Final Report - Corrections Required **Application No. LUPL-25-0008**

Report Date: 12/12/2025

Document Filename : 241010_BLR Village C Land Use Plan.pdf

ISSUE RECORD

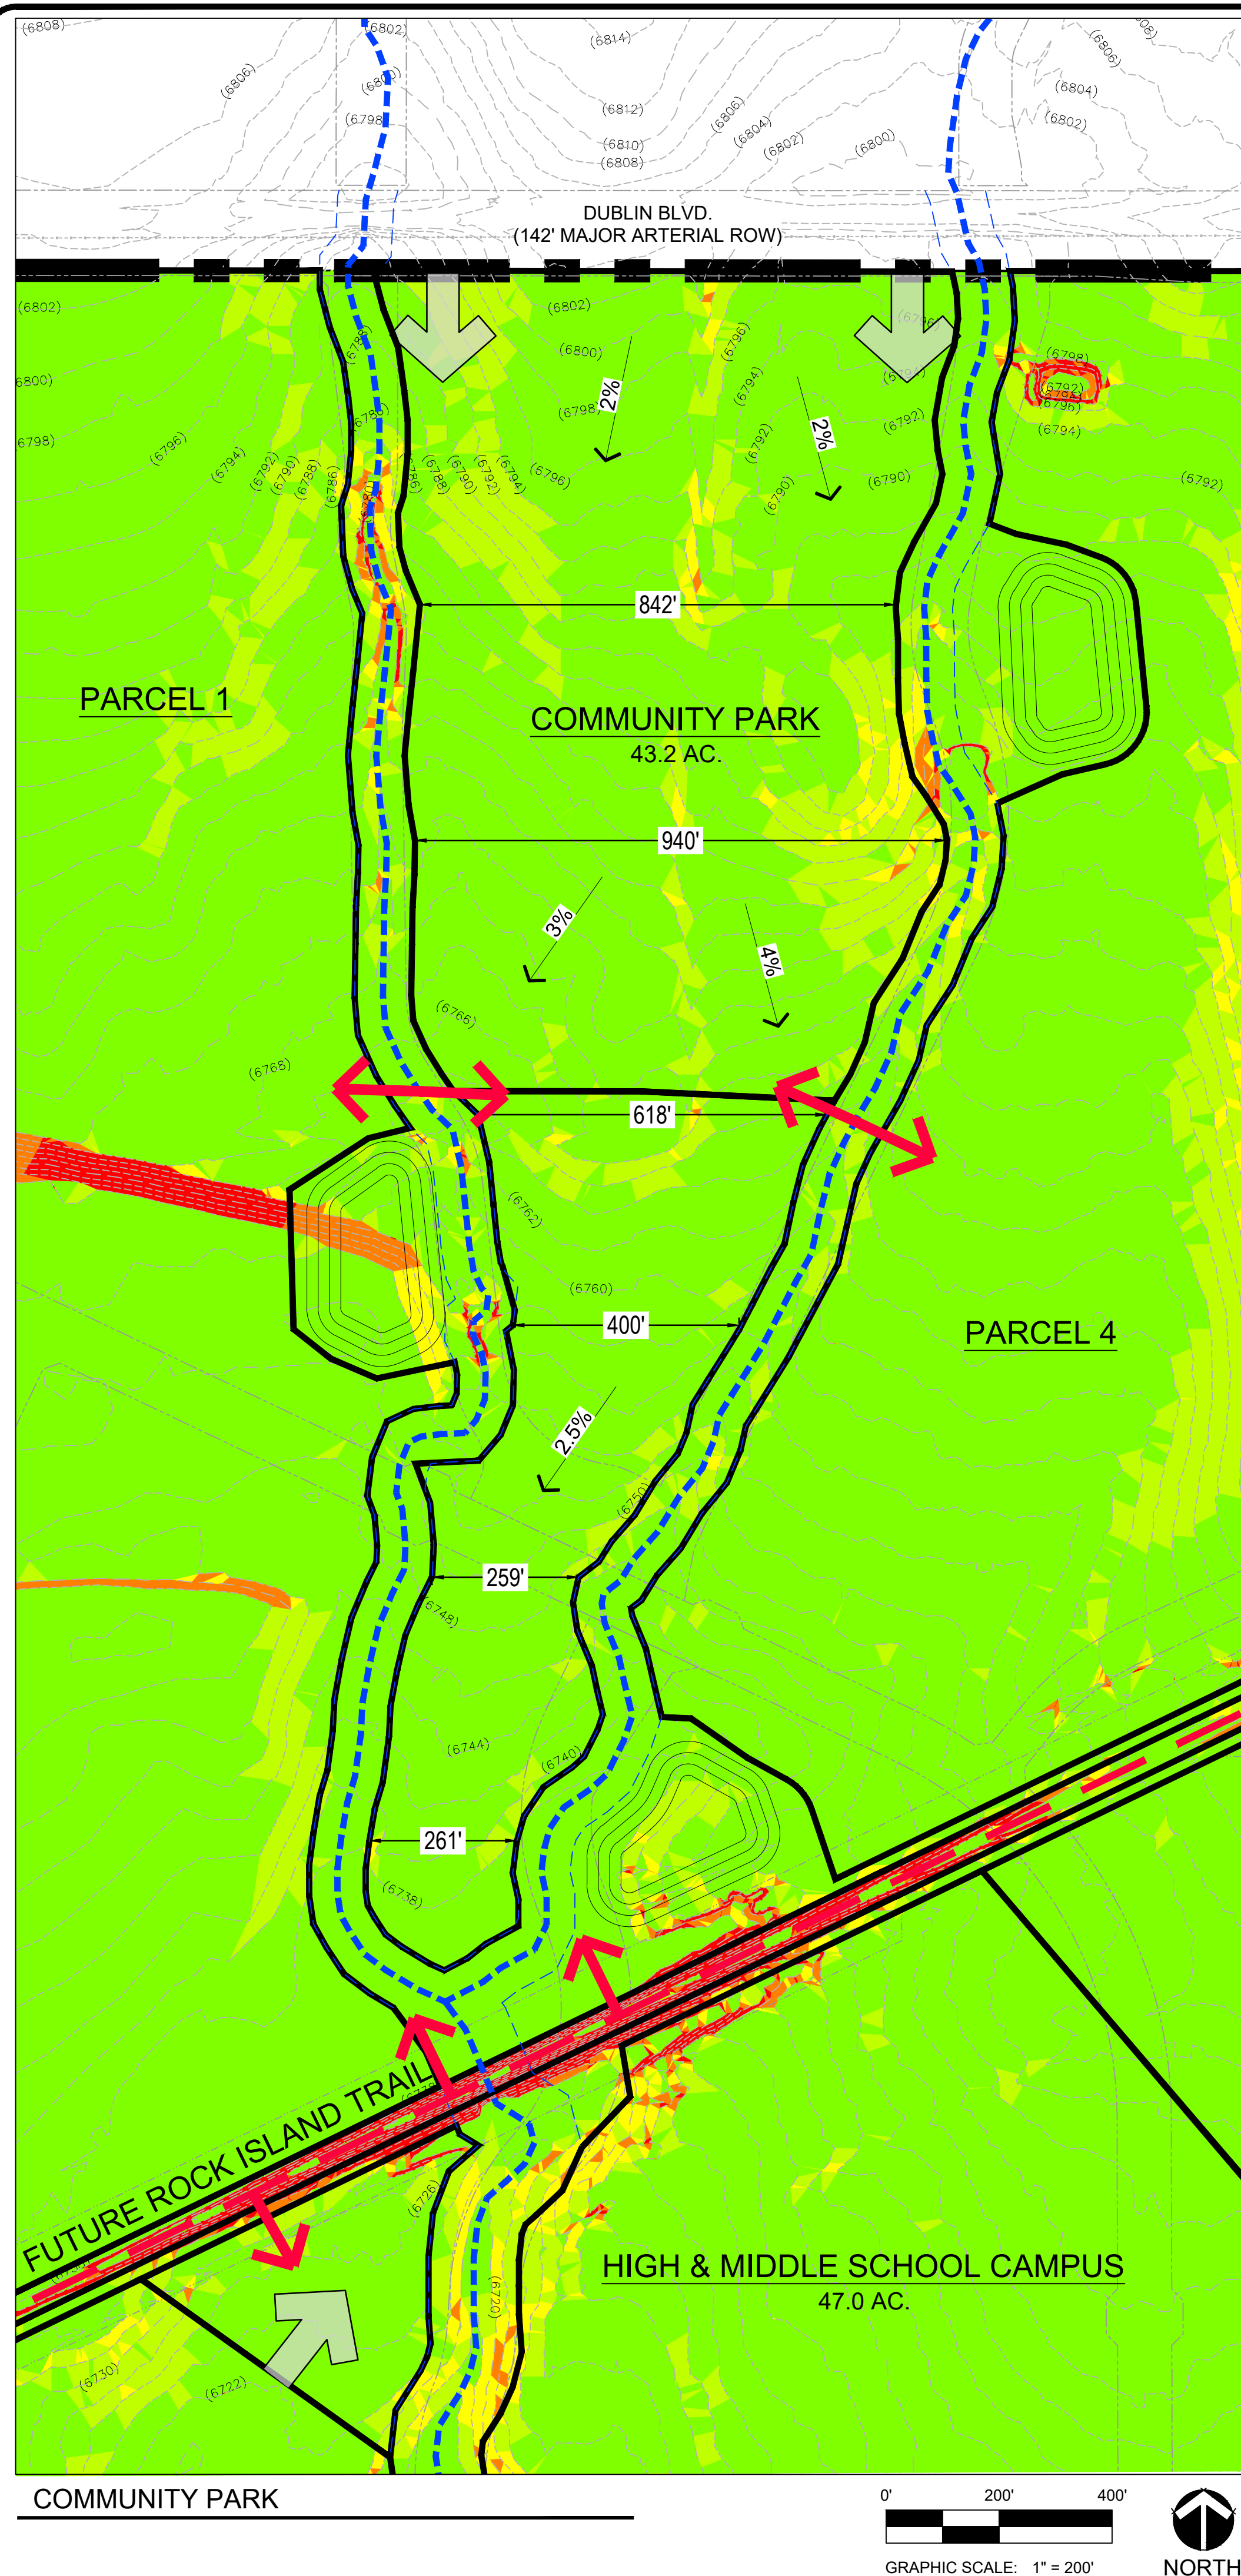
Comment ID	Page Reference	Reviewer : Department	Review Comments
15	1	Caroline Miller : Planning	<p>PLDO Reviewer would like for Village B2 and C to go to Parks Advisory Board prior to City Planning Commission to highlight PLDO obligations through the Master Plan/Land Use Plan and how they are to be met through the spread of Neighborhood Parks and summed Village C Community Park site. This will take two months, the first month as a presentation item, the second month as an action item, once Parks comments are resolved on Village C.</p> <p>In addition, Parks is awaiting feedback regarding the developer building the Community Park, then dedicating it to the city. A Community Park amenity list was provided in April to help the conceptual feasibility discussions. Notes will likely be added to this LUP in the future, upon developer response.</p>
25	2	District #49 : School Districts	PK-8 proposed
